APEX ENERGY EXPLORATION DRILL PROJECT – PROJECT APPLICATION 07-0103
RECOMMENDED CONDITIONS OF APPROVAL

ATTACHMENT 1**COMMENTS AND AMENDED/ADDITIONAL STATEMENT OF COMMITMENTS**

Figure 2. Original and New Location for AI05.

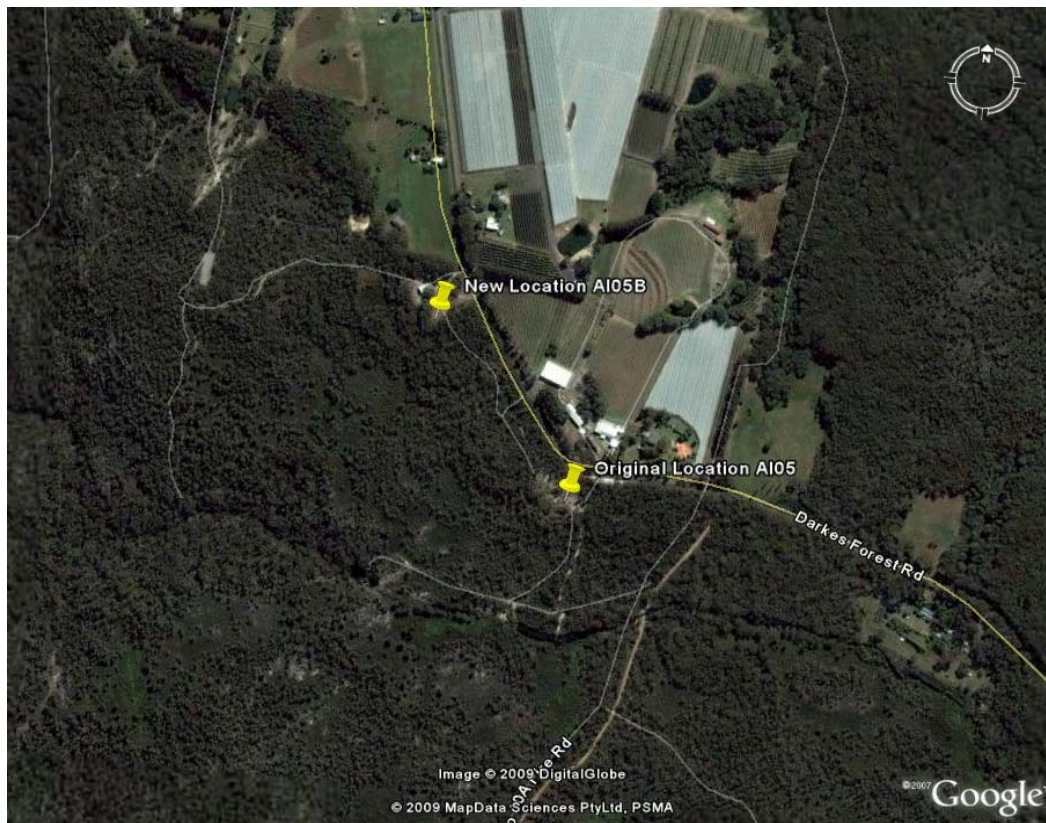
The EA states that Borehole AI05 is located within the Dharawal SCA. In earlier discussions with Apex Energy, the Department advised that the location of Borehole AI05 is situated in habitat which a number of frog species inhabit including the vulnerable Giant Burrowing Frog which has both state and national conservation significance. This species was also identified in the EA. In these earlier discussions, Apex Energy advised the Department that they had an alternative location for this borehole in the adjacent private land approximately 50m north. The EA does not appear to have considered this alternative location as previously discussed. Given that there appears to be an available alternative location and that the proposed site is situated in significant habitat for this species, the Department is not in a position to support this borehole location. In this regard the Department recommends that DoP explore with Apex Energy the feasibility of the alternative location to address the above issues at the site.

In addition, following previous discussions with Apex Energy, the Department understands that Borehole AI05 may need to be drilled on an angle to access the relevant goaf areas to extract the gas. There was insufficient information provided in the EA regarding the angle, direction and length of drilling in relation to this borehole and any associated potential impacts. In this regard, given its close proximity to the Dharawal Nature Reserve, the Department requires that any impacts on the Dharawal Nature Reserve associated with this activity are prevented and the permissibility of drilling in relation to the Nature Reserve must satisfy the requirements of the Plan of Management.

Figure 4. Original and New Location Borehole AI10

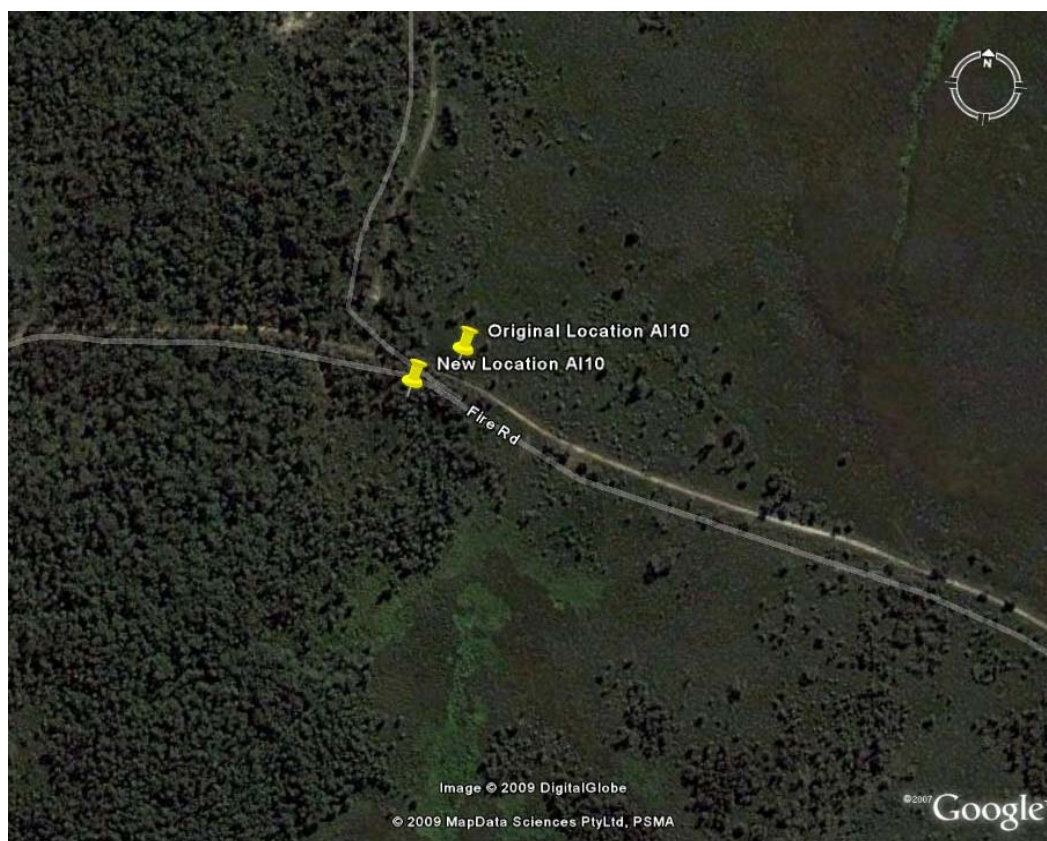
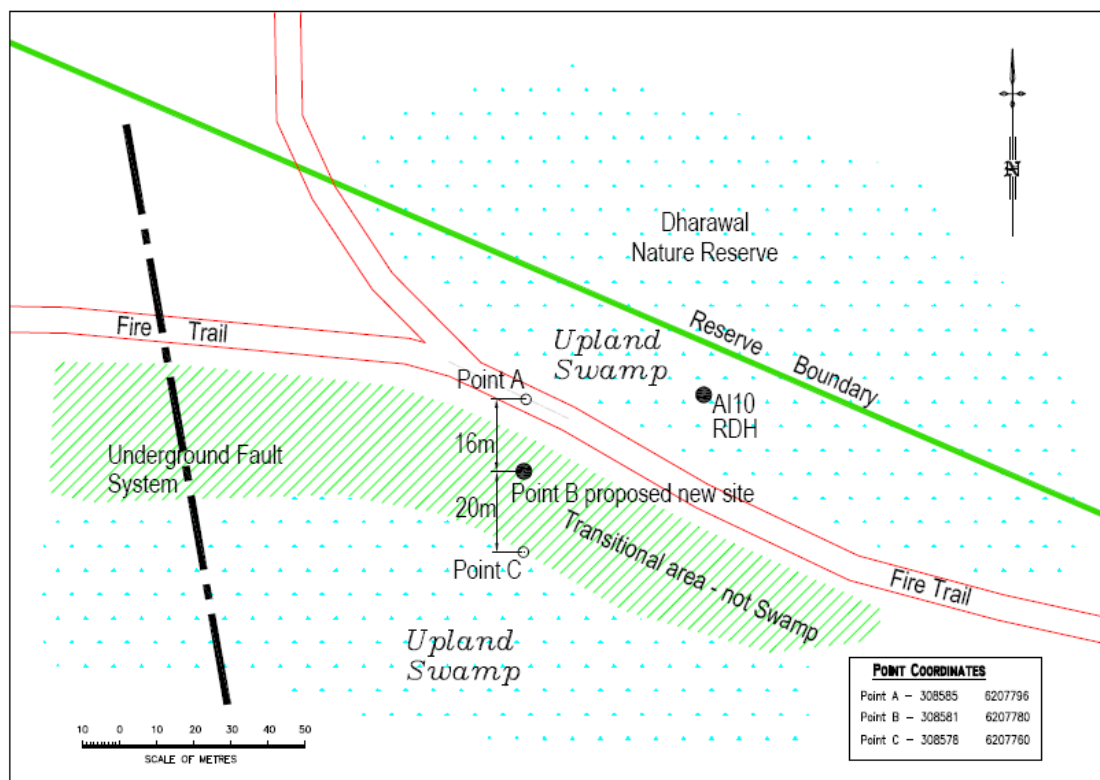
Given the sensitivity of Coastal Upland Swamps, their uniqueness to the Woronora Plateau and their links with the hydrology of the area, the Department would not support the clearing of the proposed 1.2ha of Coastal Upland Swamp associated with Borehole AI10. The EA does not appear to provide any justification for the selection of this site and nor does it describe any other potential alternatives. In this regard the Department recommends that DoP explore with Apex Energy the feasibility of alternative locations for this site which address the above concerns.
